BOGNOR REGIS TOWN COUNCIL

31st October 2019

Re: Planning applications BR/120/19/PL and BR/121/19/L: The Bandstand, The Promenade, Bognor Regis

DWG NO 824/04

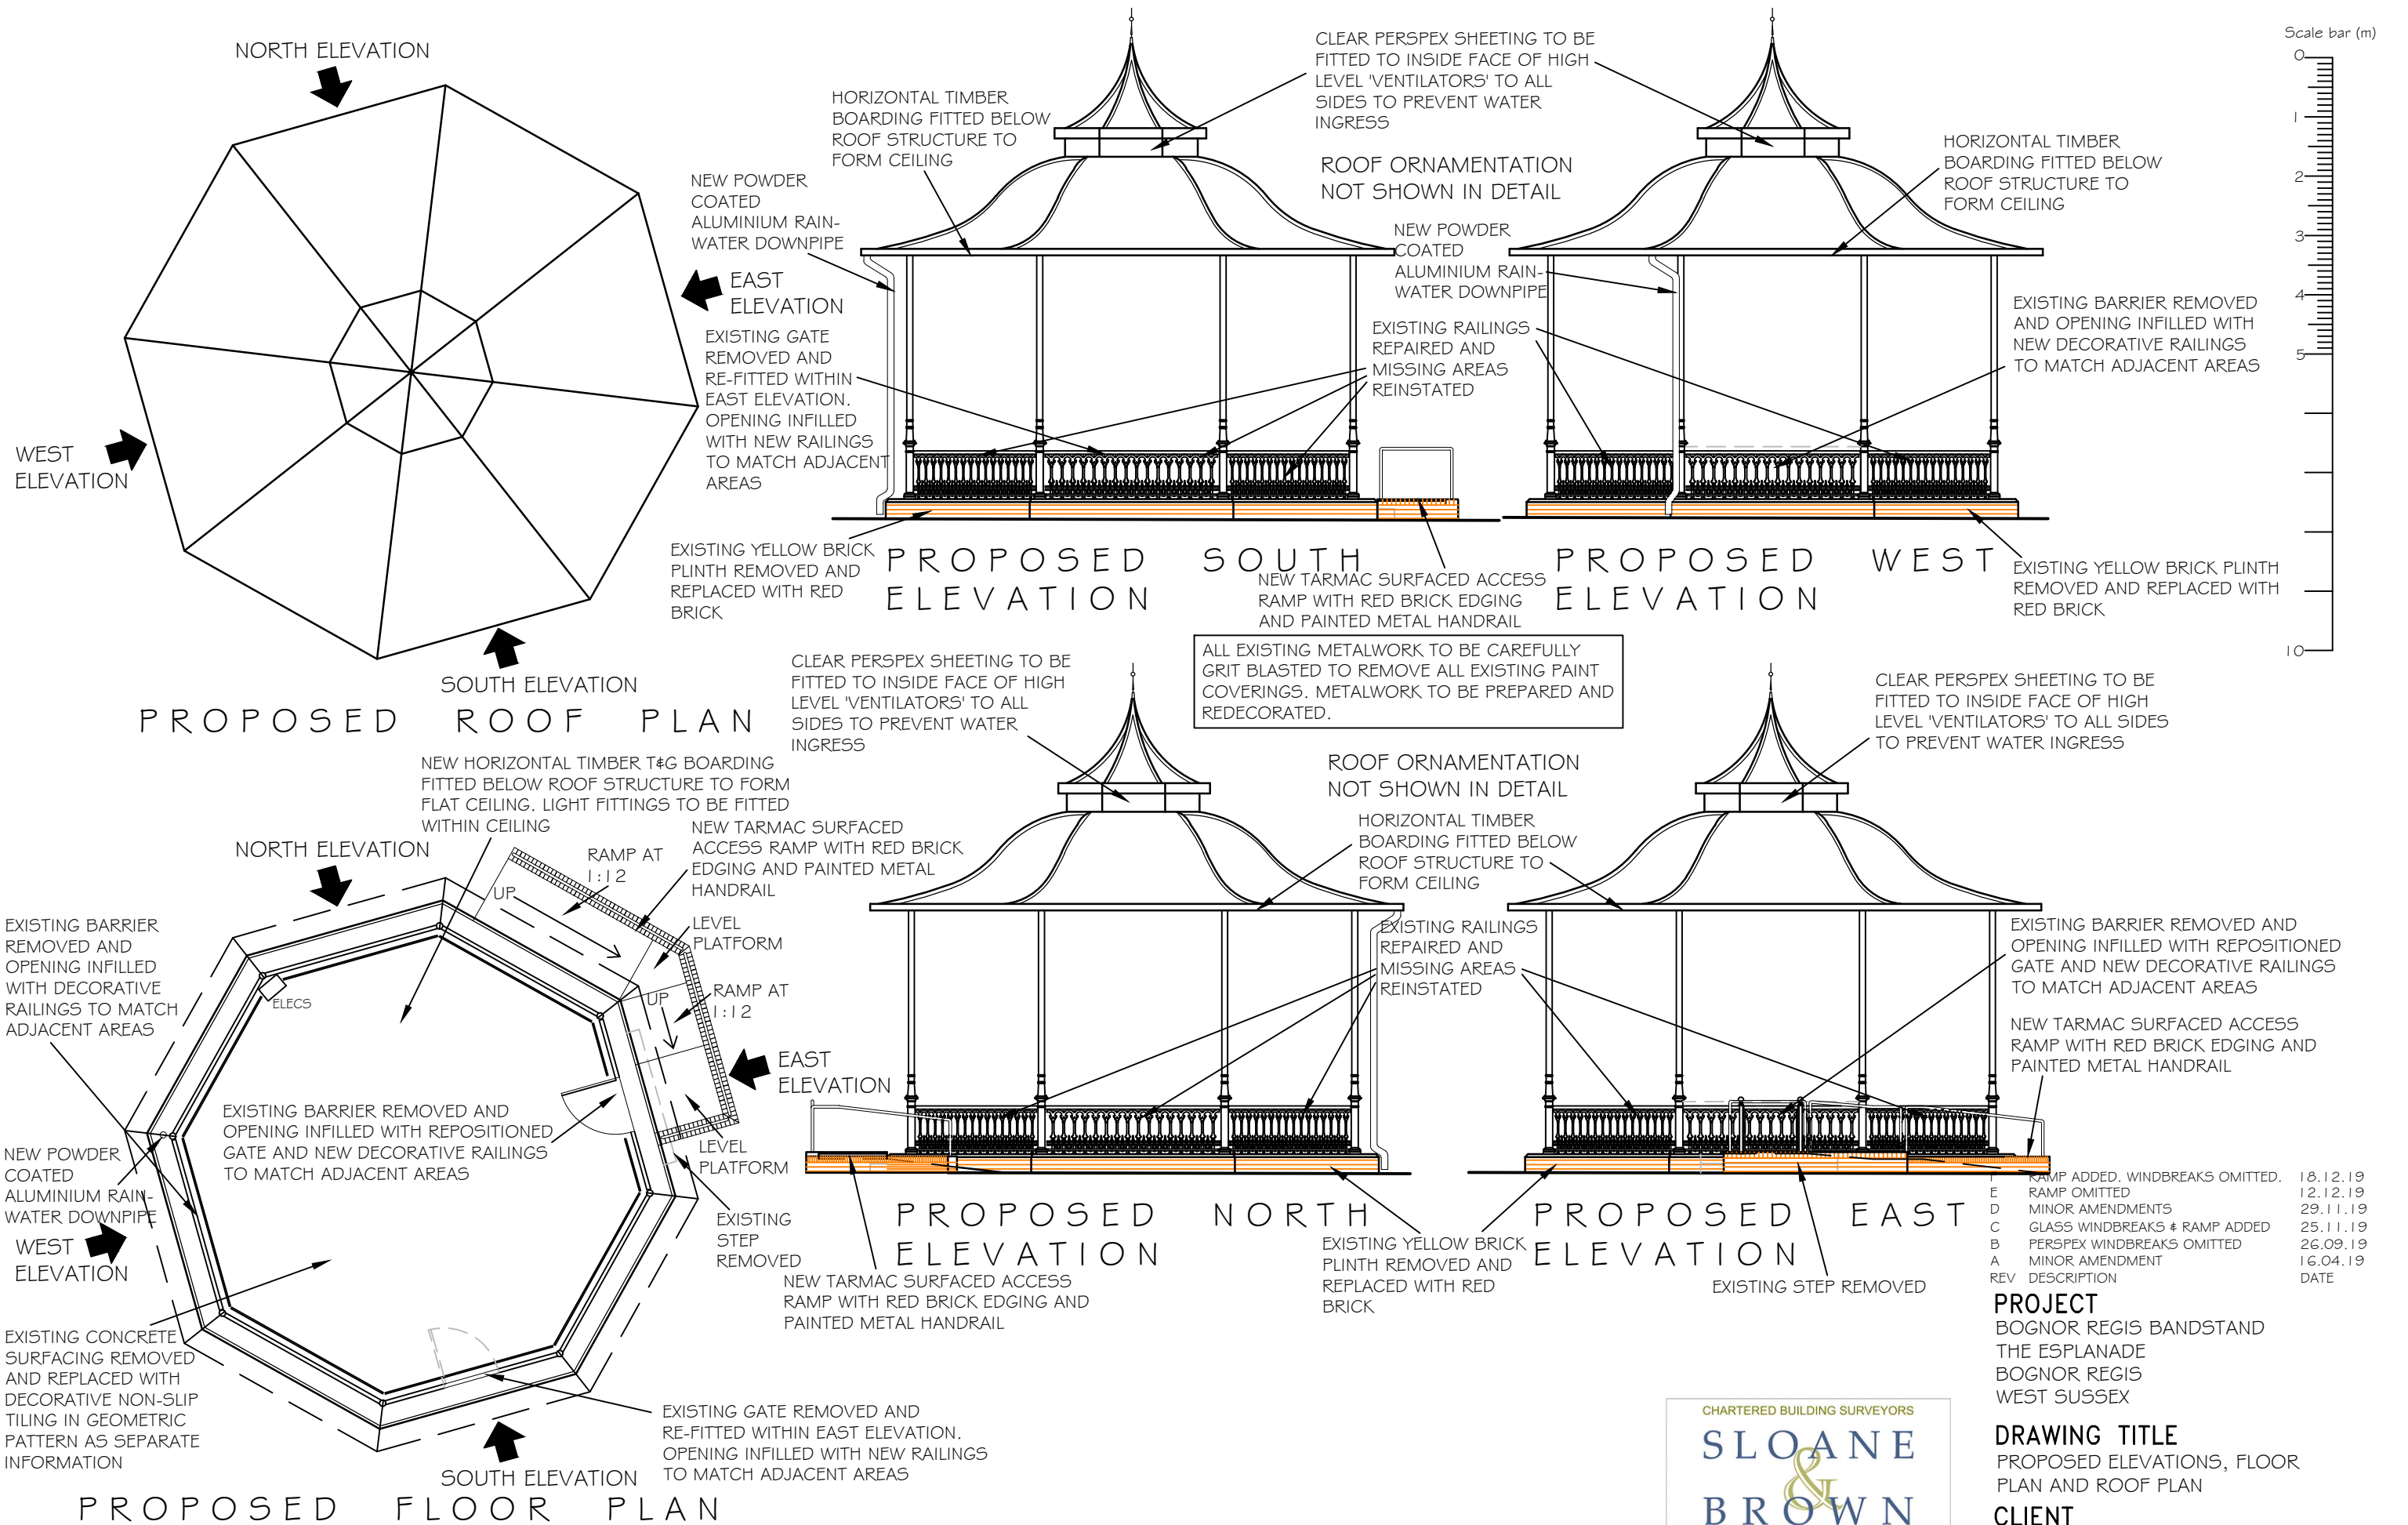
Whilst Members acknowledged the omission, for now, of the previously proposed Perspex sheeting to the railings there remained concern about the safety of Perspex being fitted at high level, particularly during high winds.
